**CITY OF ALBUQUERQUE
PLANNING DEPARTMENT**

**April 8, 2015
DRB Comments**

PROJECT # 1010414

RE: Lots 77 & 78, Block 22, Anderson Heights, Units 7 & 8

**SKETCH PLAT AND SITE PLAN OF  
LOTS 77-A and 78-A  
BLOCK 22  
ANDERSON HEIGHTS UNITS 7 & 8**

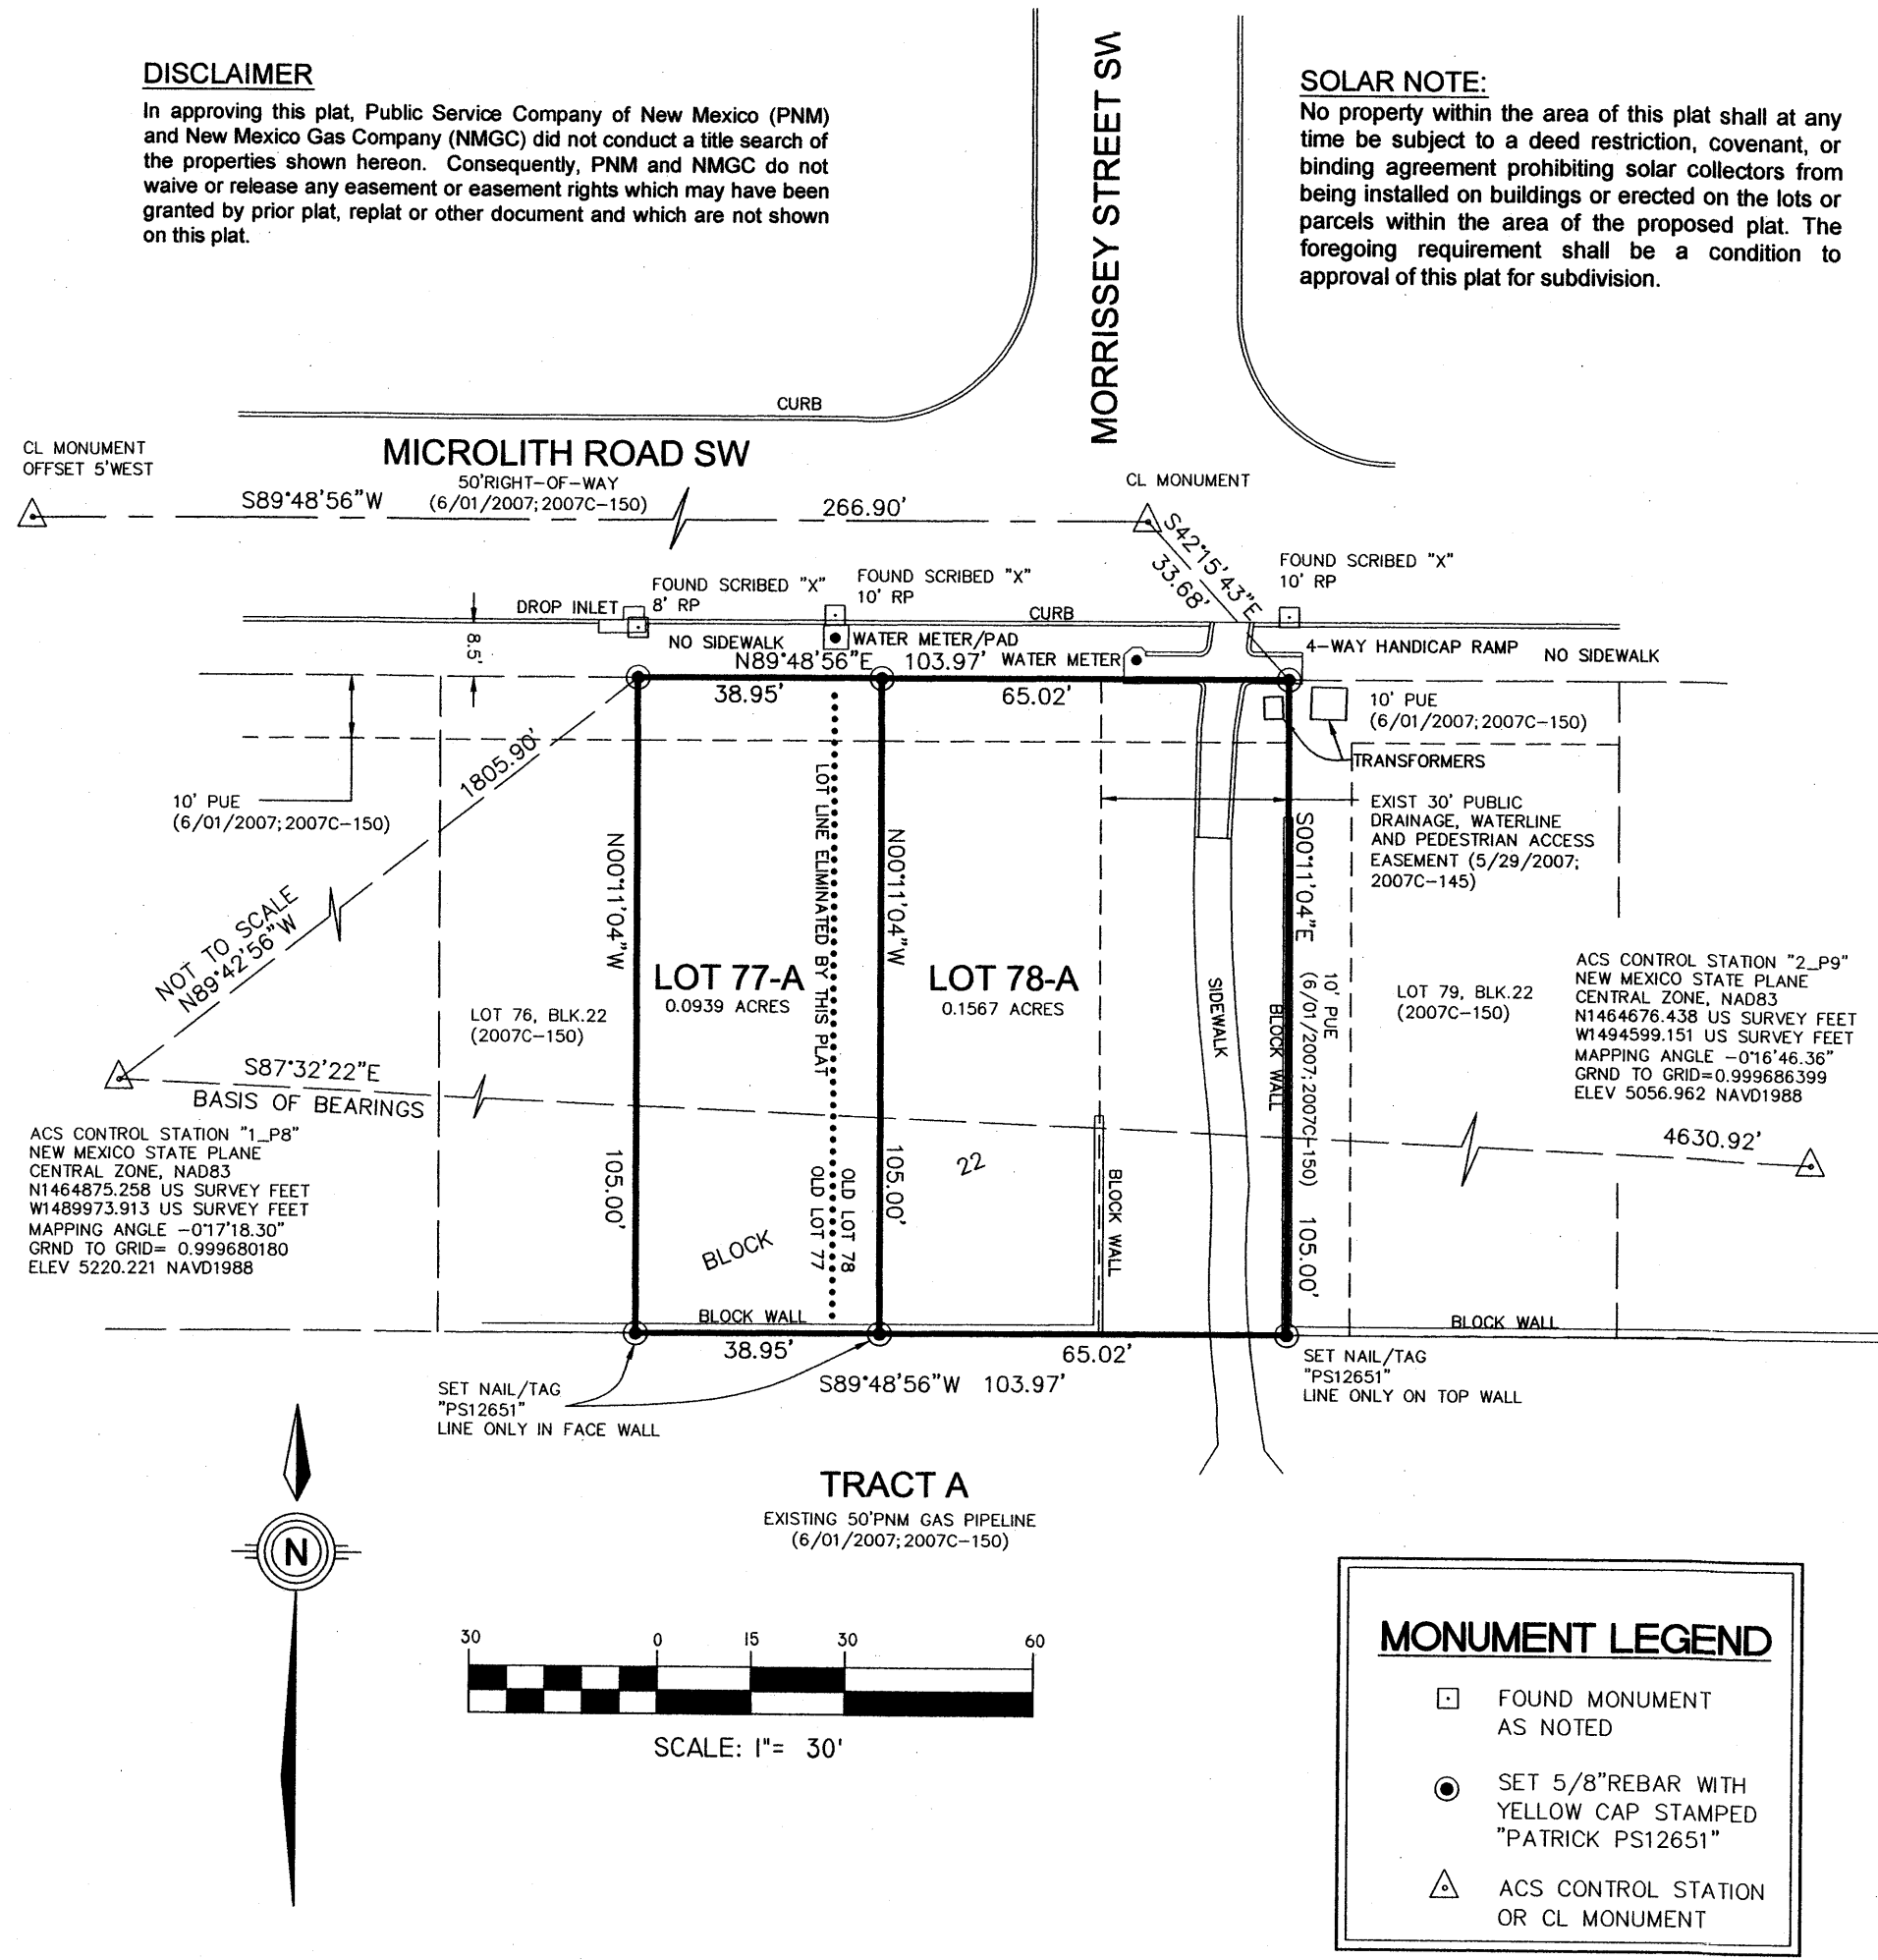
Proposed changes to Lots 77 & 78 would still allow townhouses (attached). If applicant wants detached houses then the minimum lot width would need to be 40 feet per the R-LT zone.

On the final plat, please remove zoning note.
